Your Ref: OWPC17682
Our Ref: AW/25/18/HH 24-01-2018
Please ask for:
Mark Jones

Two storey rear extension (resubmission following AW/271/17/PL). This application also lies within the parish of Pagham.

36 Apple Grove Aldwick

Ground Floor Proposed 1:100

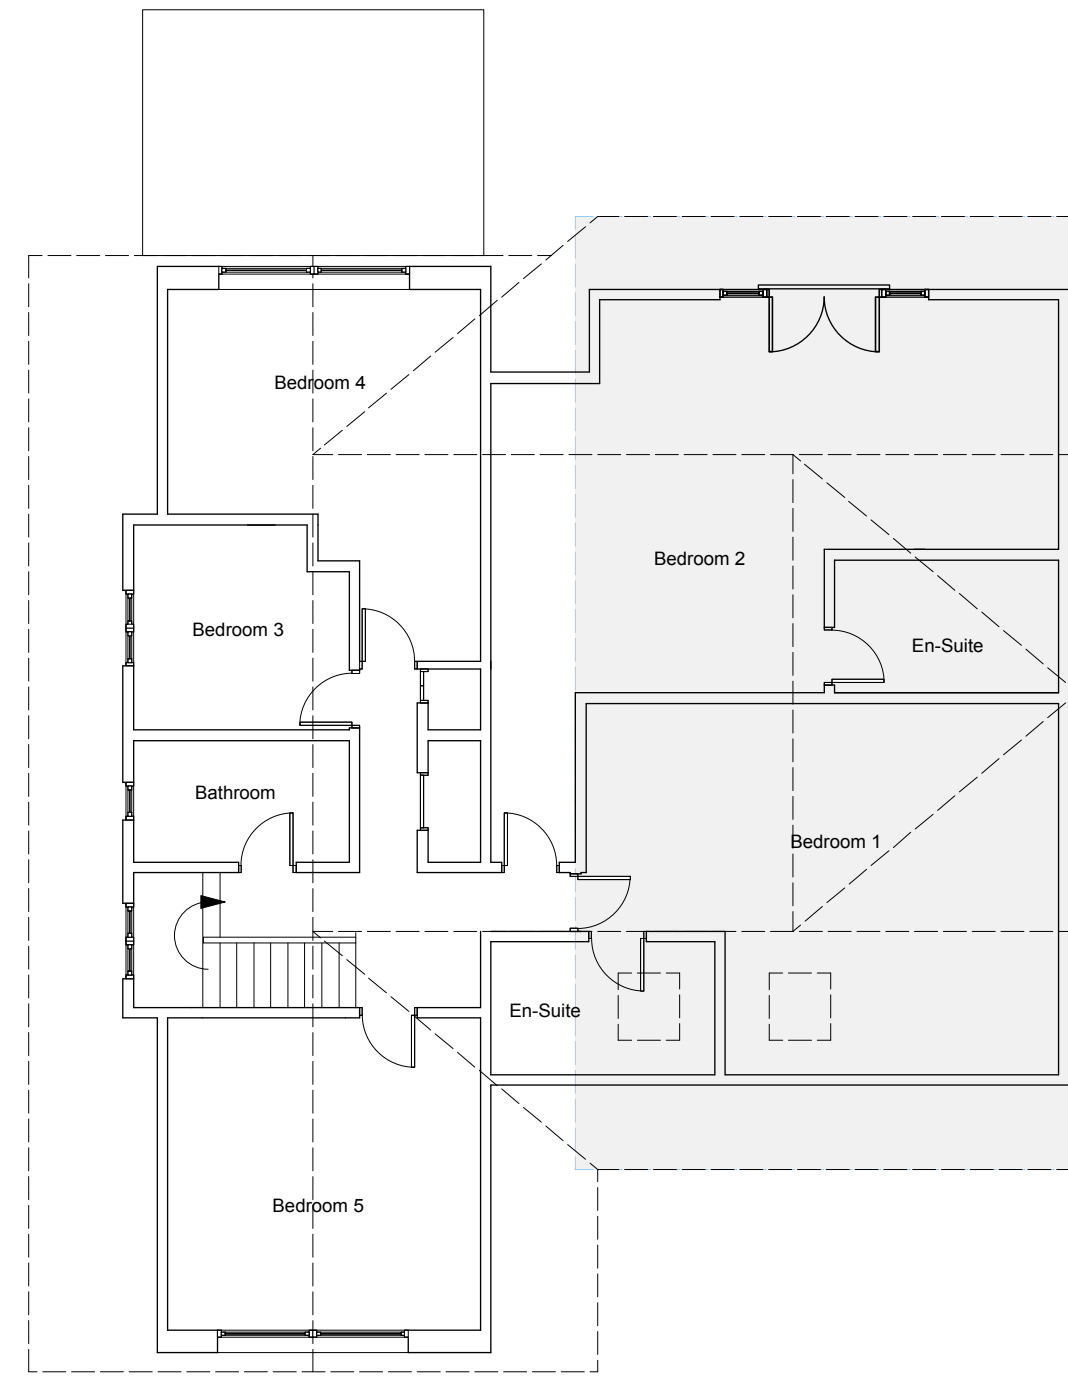
It has been brought to my attention that the proposed plan shows the existing garage named as "kitchen". This is NOT our intention and a mistake on the proposed plan. The proposed plan area named "kitchen" should read "GARAGE" and will remain unchanged internally . Kind Regards - Doug Millen (applicant)
